RE: BP-2020-56517 Cheba Hut Expansion @ 115A Harvard Dr SE - AA for #1004927

This letter is to justify modifications to be made to the existing approved Development Plan. The official Notice of Decision associated with the prior approval could not be located. Cheba Hut LLC is expanding into the adjoining tenant space. This will allow for extension of food line and relocation of bar and associated seating. Modifications to the existing storefront are required to accommodate new interior layout.

**CHEBA HUT - HARVARD EXPANSION**  
 115A HARVARD DR SE  
 ALBUQUERQUE NM 87106

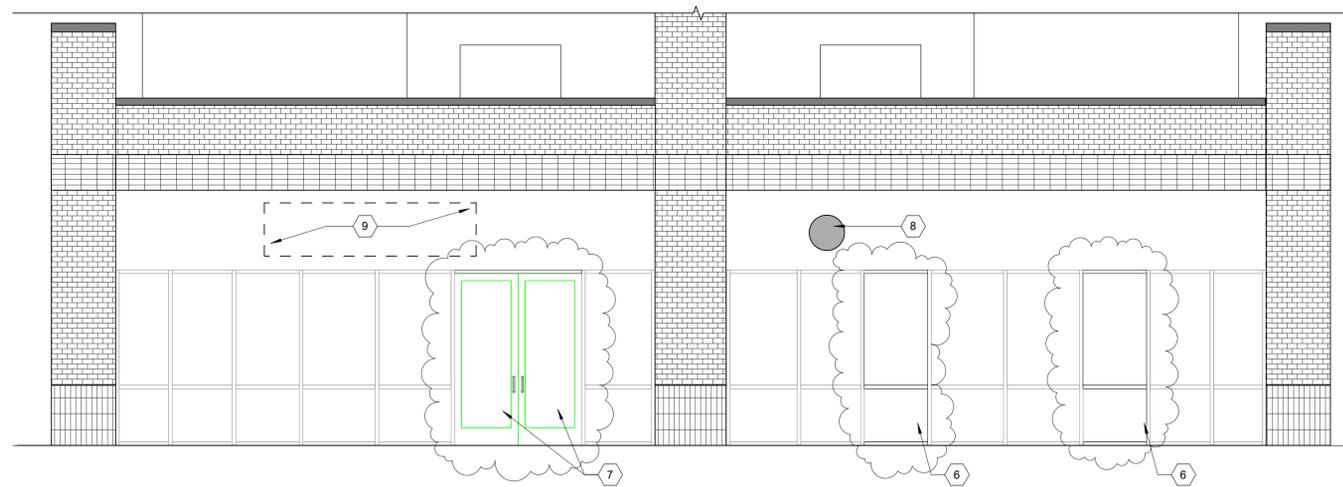
1. North Elevation: reconfiguration of existing storefront to change double doors to a single storefront door. Reconfiguration works with existing mullion pattern. Head height of storefront does not change.
2. East Elevation: reconfiguration of existing storefront to work with modified interior layout to include removal of two storefront doors and replace with fixed glazing. Existing single storefront entry to be made into a double door. Reconfiguration works with existing mullion pattern. Head height of storefront does not change.
3. South Elevation: reconfiguration of existing storefront to allow for overhead coiling door at bar and existing double doors shall be made a single storefront door. Head height of storefront does not change.
